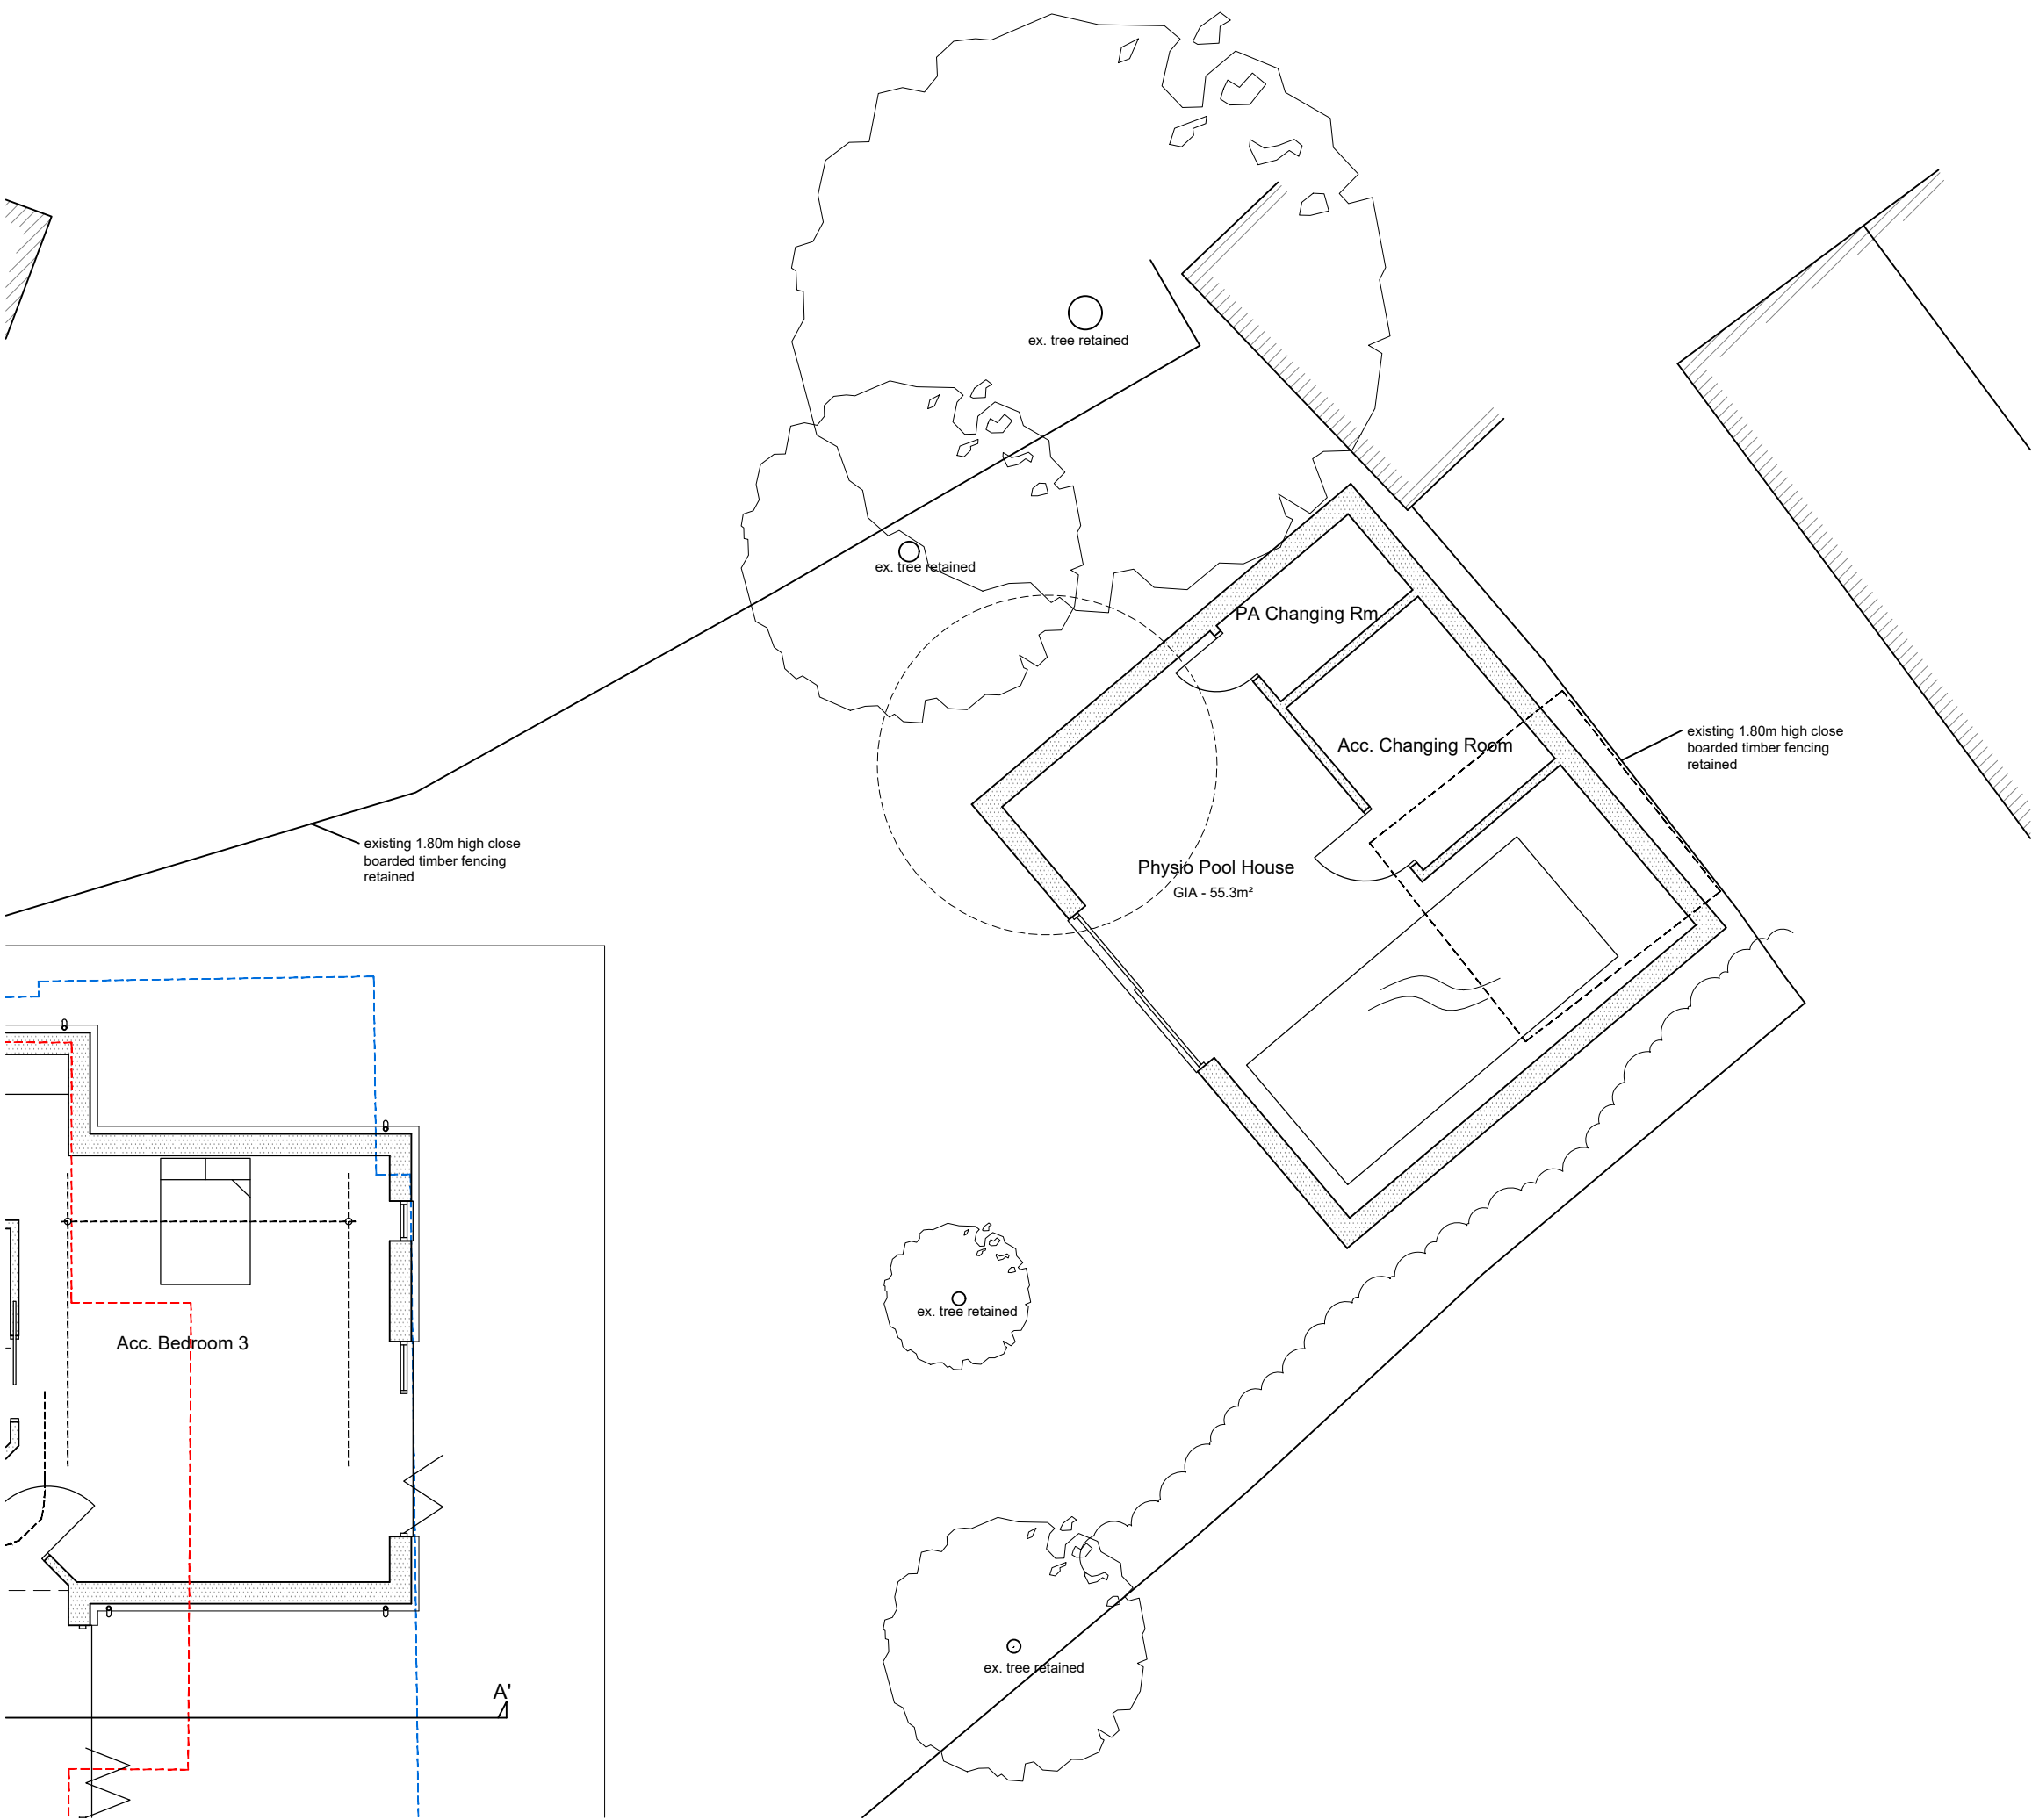
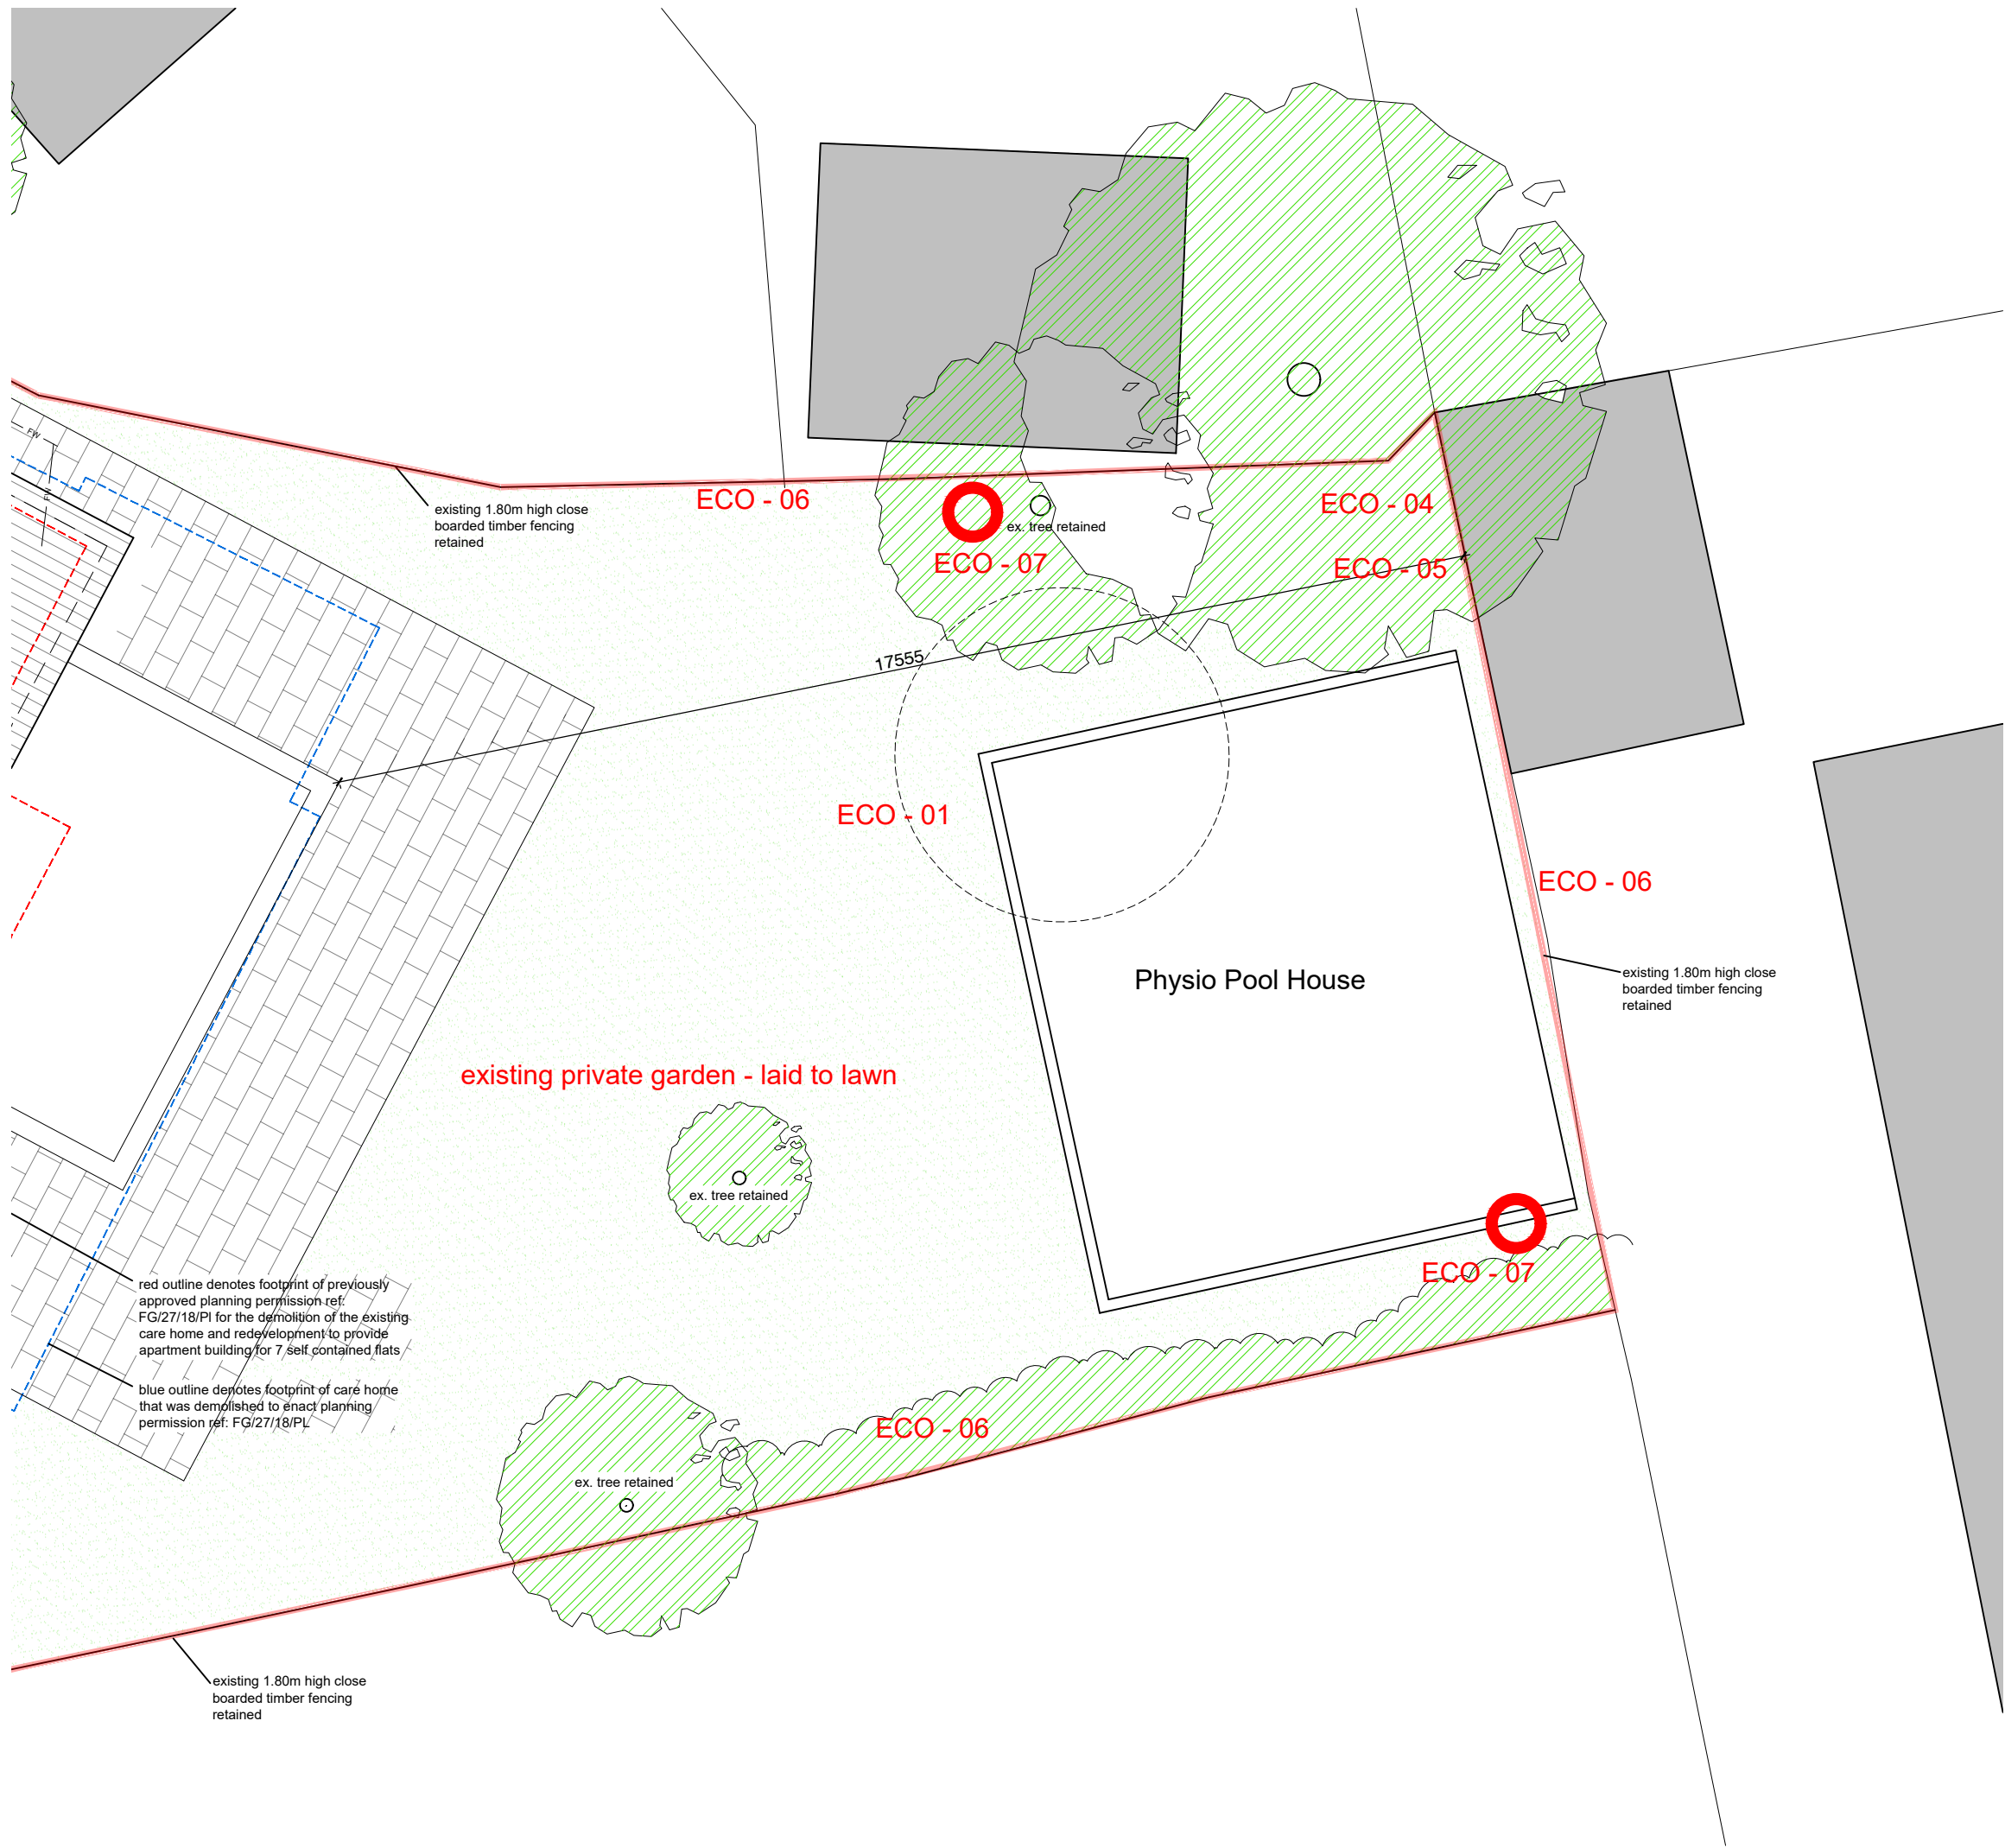
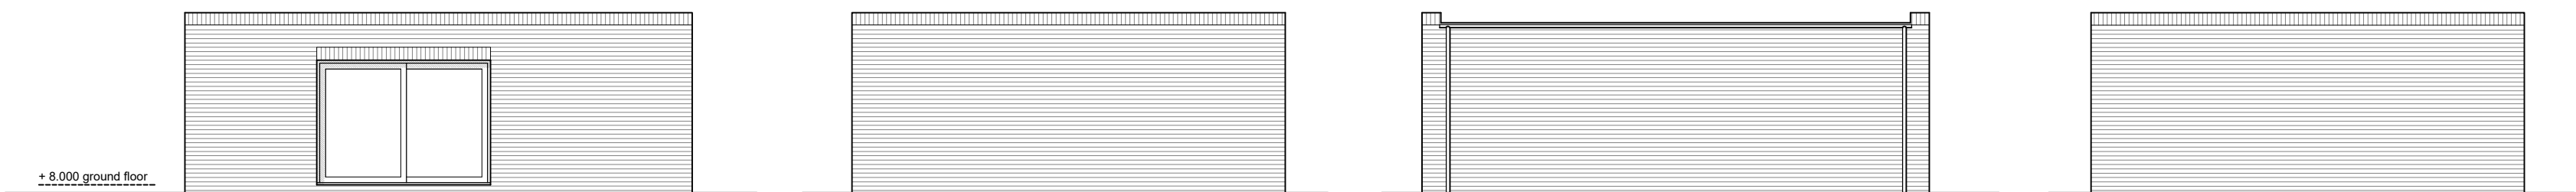
We have received an email from the neighbour at no.2 Grange Park questioning the change from flat to pitched roof for the pool house, and suggest significant impact from such a high ridge height. I had wondered this myself as it is a very high ridge height at 6m due to the equipment I think?

I have checked this with my Manager and they have said 'Given outbuilding is due west of one to rear think flat roof version has less overshadowing/overbearing impact.'

As such, sorry to be a pain, but can you send me please the amended physio pool drawing sheet with the flat roof instead? I'll then swop that back in.

No problem at all, amended pool house drawing attached and for completeness, the amended proposed site plan too.
